## Review Response

Project Name: Lott Dock Project

Response To: PRE24-002

EXISTING CONDITIONS

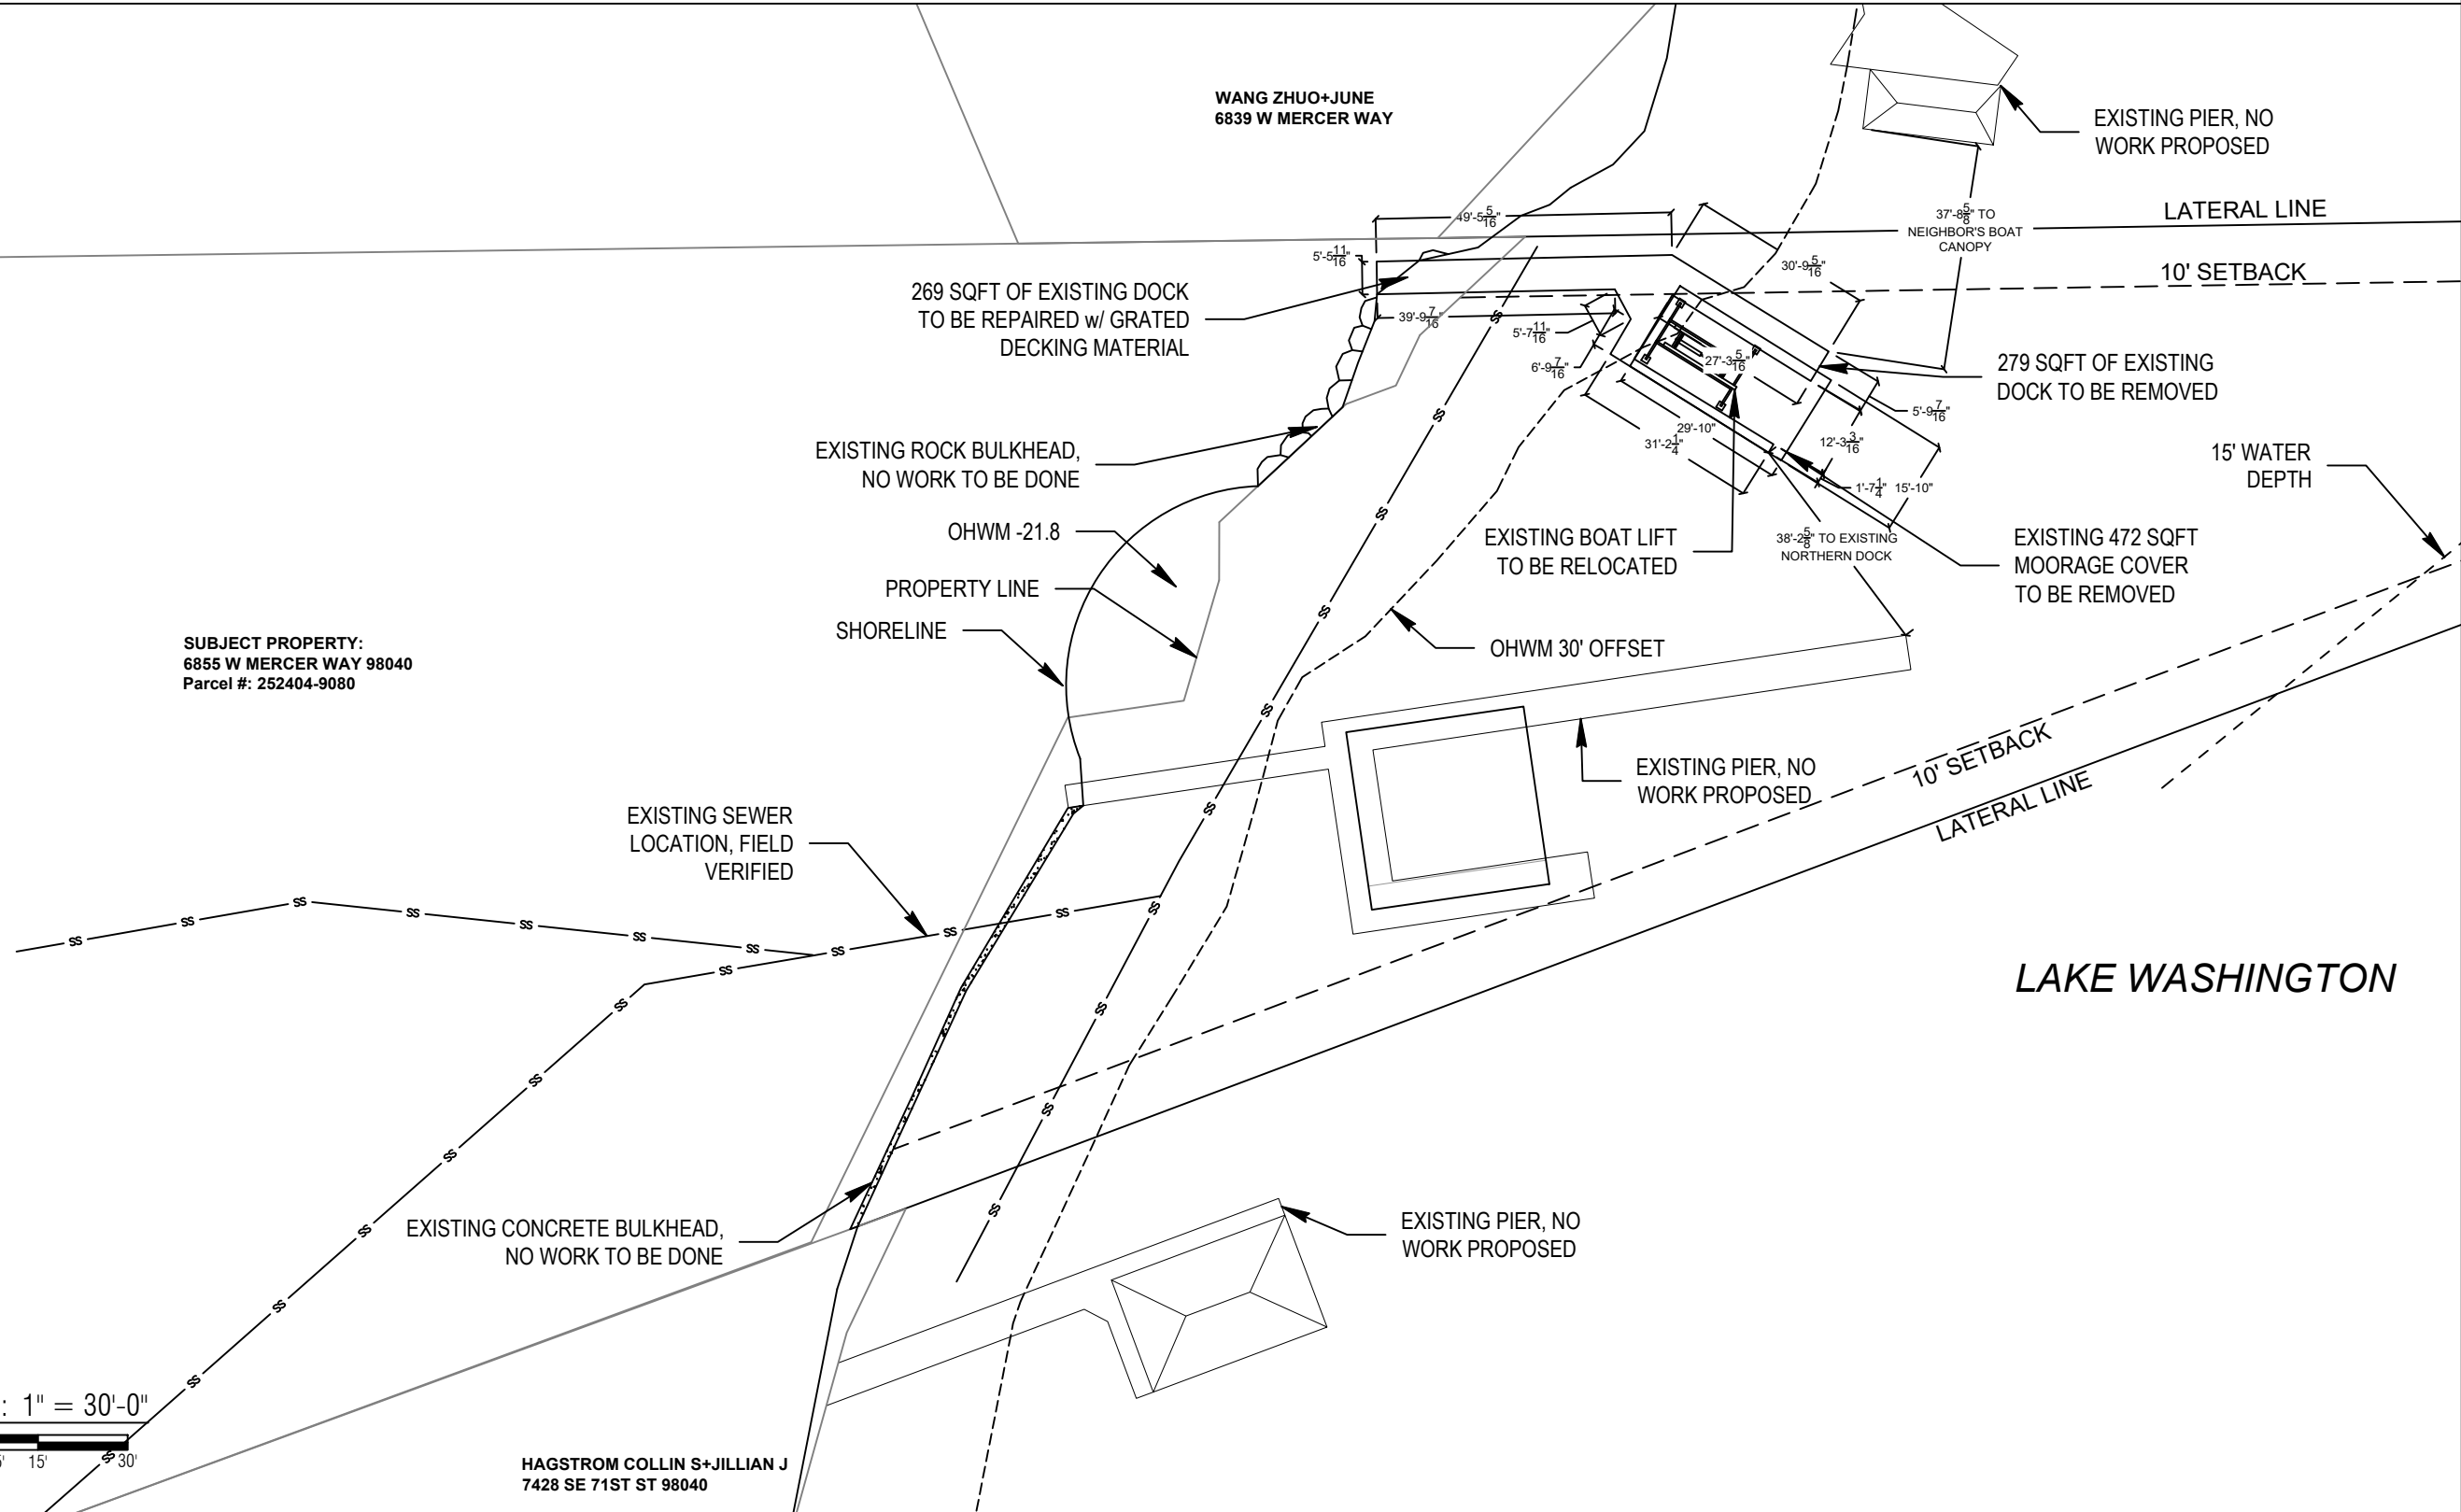
1. Project does not comply with WAC 173.27.040. SEPA and SSDP application and documents included with submittal files.
2. Code compliance under MICC 19.13.050(F)1 narrative demonstrated on sheet 2 of the submittal plan set.
3. Narrative for legal nonconforming pier and code reference for its continuation added to narrative.

EXISTING PLANT PLAN

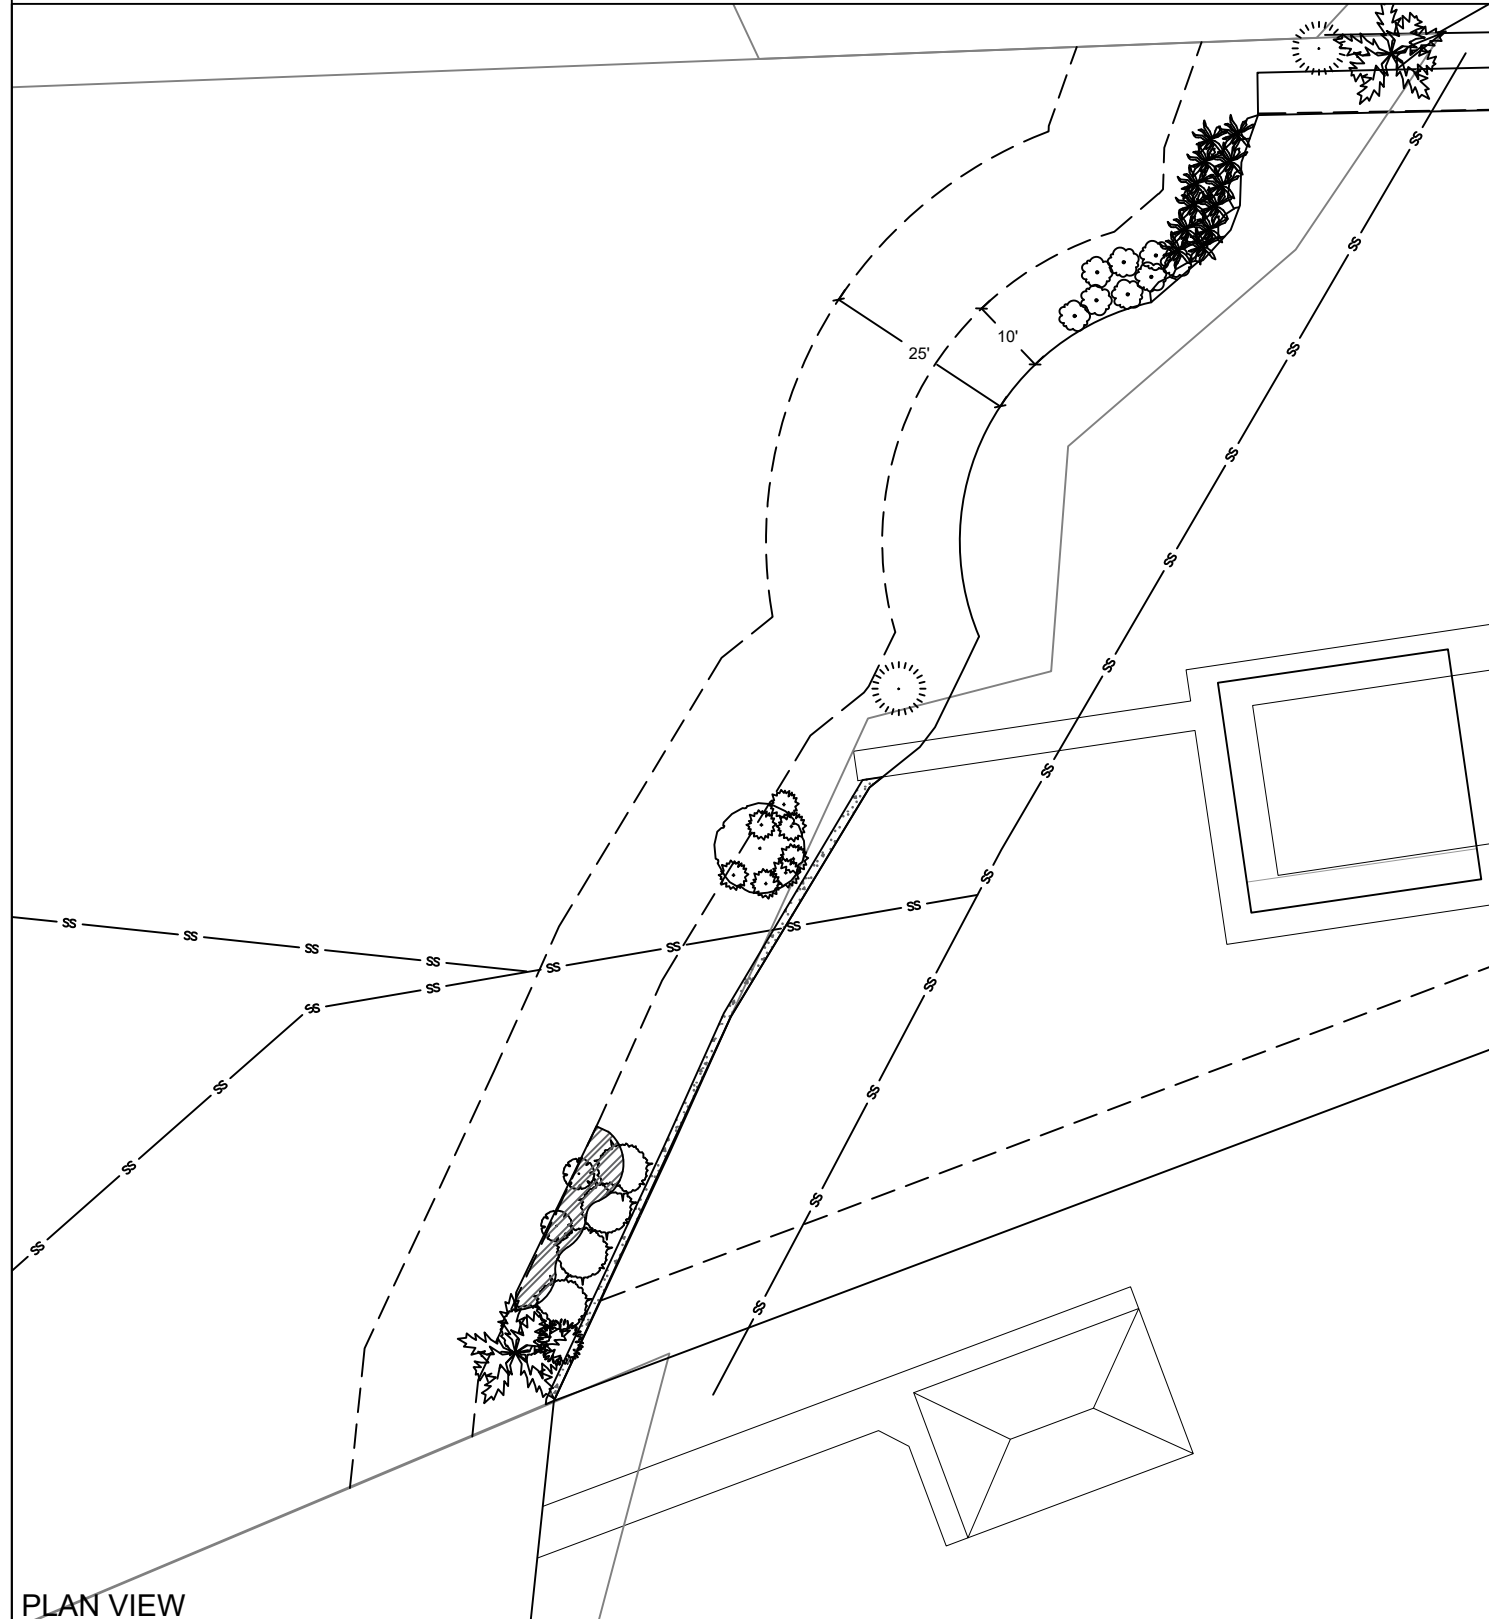
1. Existing trees and shown on plan set. Drip lines represented by outside radius of the symbols. Species, quantity, and sizes noted.
2. No recent building permits for additions or new buildings per MICC 19.07.110(E)(9)(d).
3. No trees will be impacted by this project.
